**WELWYN HATFIELD BOROUGH COUNCIL
DIRECTORATE OF STRATEGY AND DEVELOPMENT**

DELEGATED APPLICATION

Application No: 6/2016/0234/PN3
Location: Nyn Manor, Vineyards Road, Northaw, Potters Bar, EN6 4PQ
Proposal: Erection of agricultural building for storage
Officer: Mr M Peacock

Recommendation: Refused

JOB No.	1747
DWG No.	SK10A
SCALE	1/200 @ A3
DATE	DEC 2015
DRAWN	PH
CLIENT	A NEWLAND

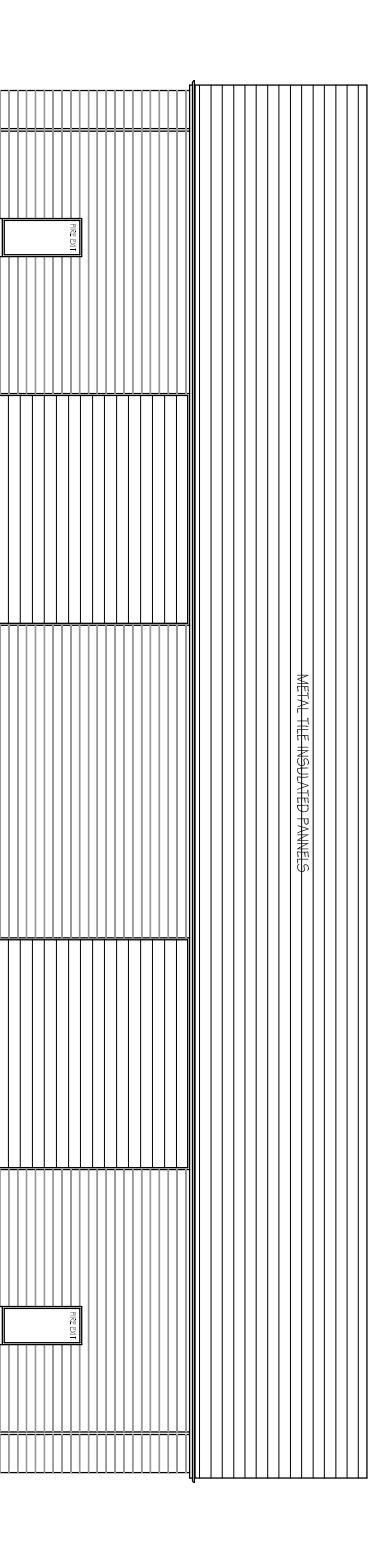
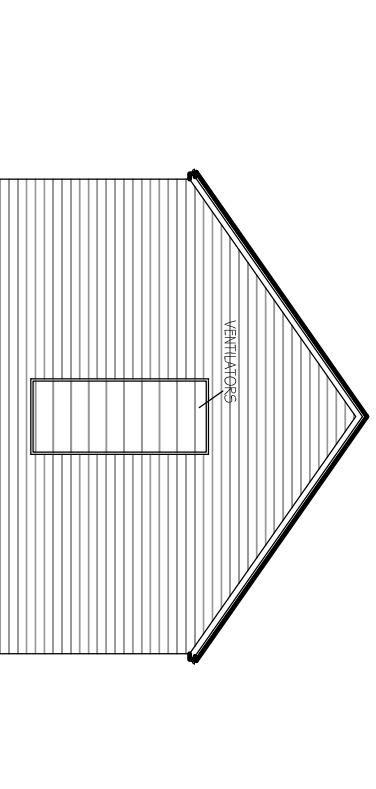
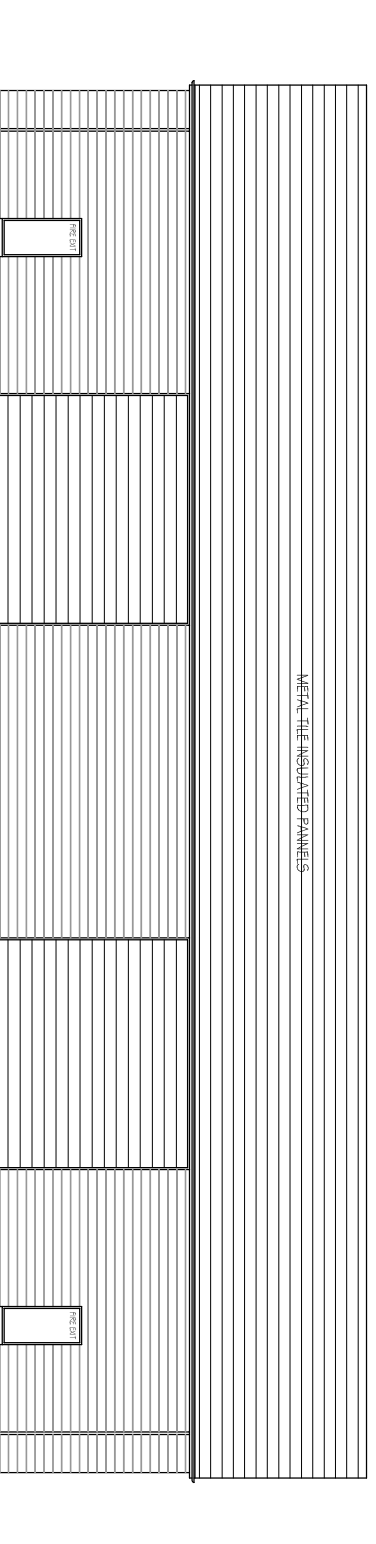
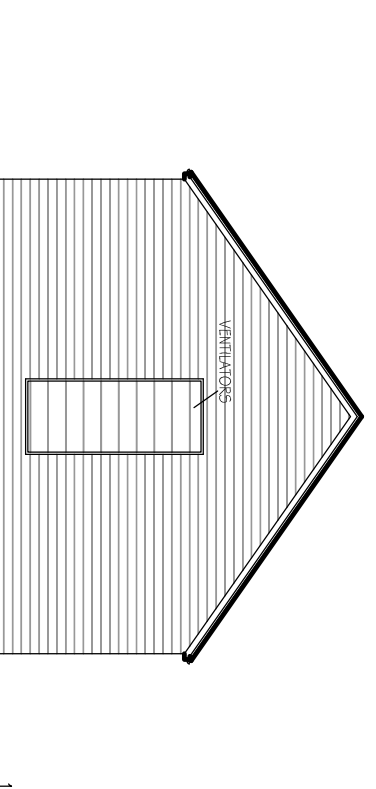
<p>Design and external appearance</p>	<p>The proposed building would measure 36.5m x 12.5m with an overall height of 9.8m (5.1m to the eaves). The walls of the building would be finished in black horizontal timber cladding and the roof would be insulated metal in a tile form and finished in a dark red colour. These materials are considered appropriate for a general agricultural storage use.</p> <p>There are no large trees, hedgerows or existing buildings within close proximity to offer any significant degree of screening to the proposed building. The building would be prominent in views from the residential properties fronting onto The Ridgeway and in views from an extensive area of open countryside to the south, east and west of the building. There would also be views of the building from the field immediately to the north. On the opposite side of this field, approximately 100m north</p>

<p>of the building, is a line of trees which would provide effective screening from the highway during the summer months, although the building is likely to be visible in winter. The existing ribbon of residential properties fronting onto The Ridgeway would screen the proposed building in distant from the north east.</p> <p>By reason of its size, prominent location and the limited screening available, the proposed building would appear as a visually dominant and incongruous addition to the rural setting.</p>
Any other considerations	<p>The applicant should note that this assessment does not confirm the lawfulness of the proposed building with regards to Class A of Part 6 of Schedule 2 of the Town and Country Planning (General Permitted Development Order) (England) Order 2015. This application only considers whether or not prior approval is required and, if it is, if it is acceptable to approve prior approval. To have the Local Planning Authority formally consider the lawfulness of the building under the above mentioned Class of the GPDO, an application for a lawful development certificate for a proposed use or development should be submitted.</p>

1. The proposed building, hardstanding and the access would be located in an open and obtrusive position which would unduly detract from the Landscape Character Area and the openness and visual amenity of the Green Belt. The siting would prejudice the efficient use of land as it relies on an excessive hardstanding for access and would section off a narrow strip of land which would limit its use contrary to the National Planning Policy Framework 2012 and Policies GBSP1, RA10, RA18, D1 and D2 of the Welwyn Hatfield District Plan 2005.
2. REFUSED DRAWING NUMBERS: SK10A & SK11A received and dated 14 March 2016.
1. POSITIVE AND PROACTIVE STATEMENT
